May 20, 2019

RE: Capps Boundary Line Adjustment (BL-19-00006)

TO: All Staff
FROM: Justin Turnbull, County Surveyor 
DATE: May 8, 2019
SUBJECT: County Survey Review of BLA BL-19-00006 Capps

SHEET
1
OF
2

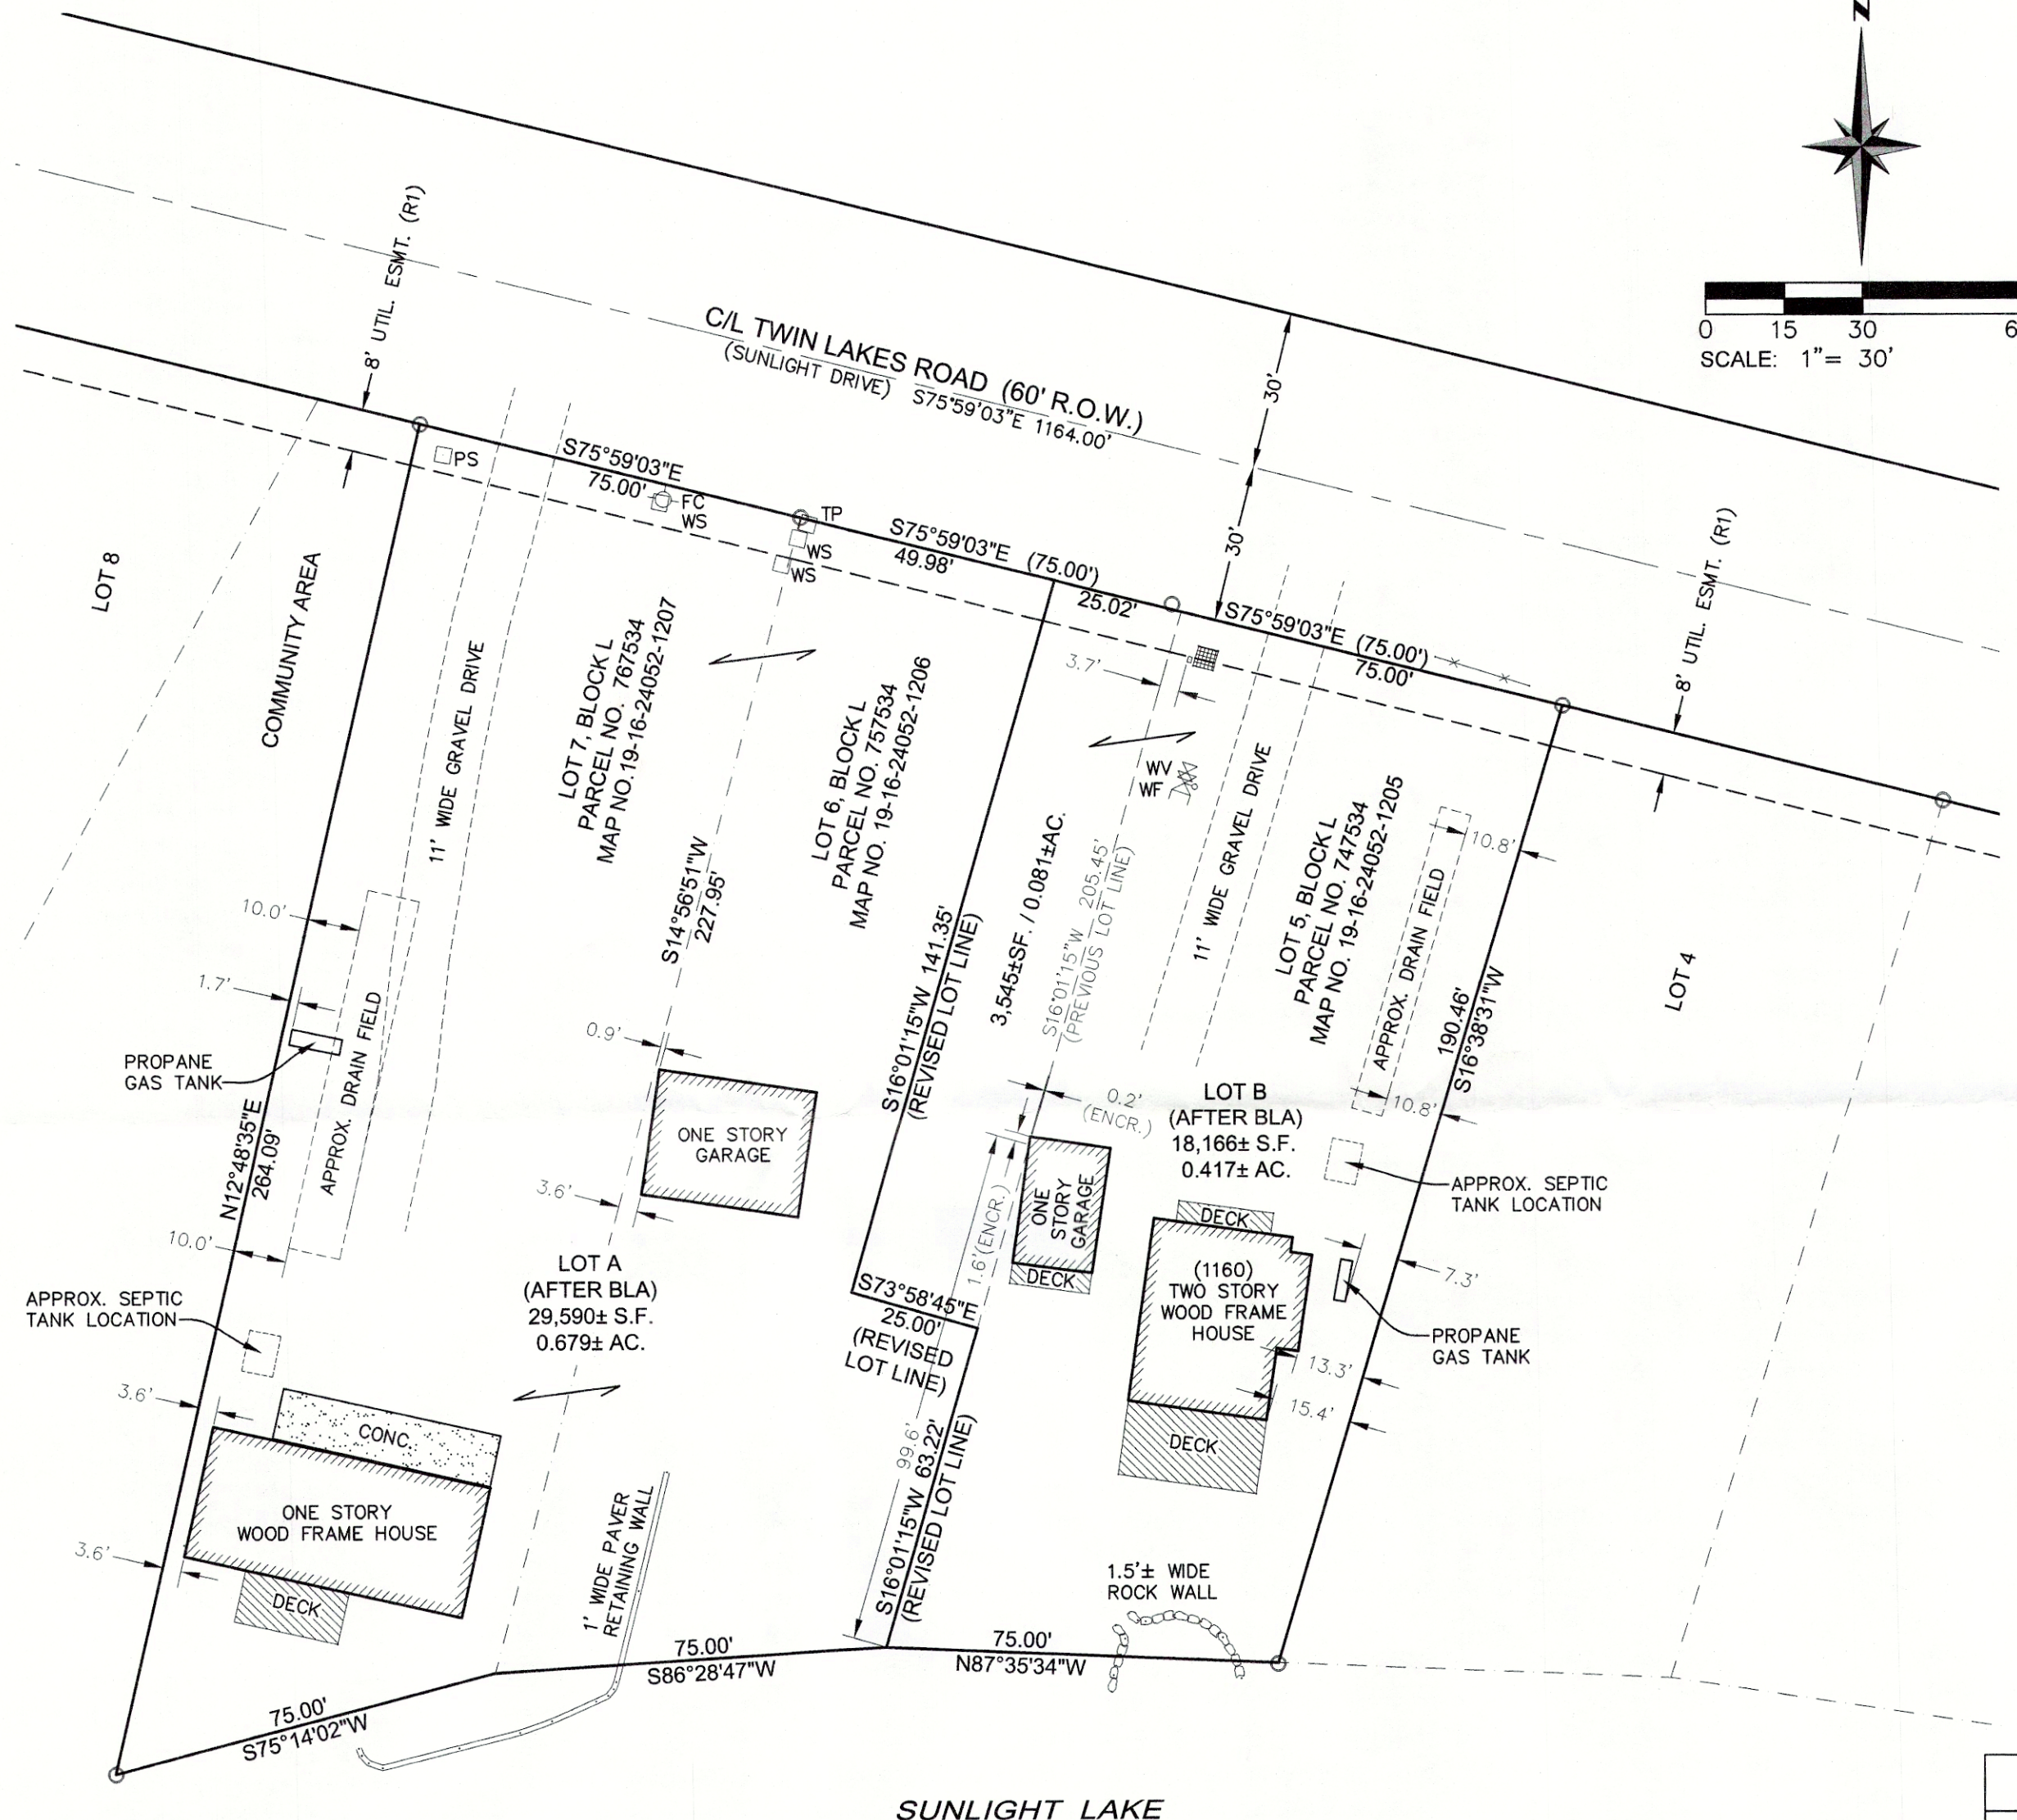
1. As a minimum, the new division line should be staked in the field, and noted on the face of the map.
2. It appears that the map uses greyscaled linework. The applicant is reminded that grey scaled linework is not suitable for the final documents to be recorded.
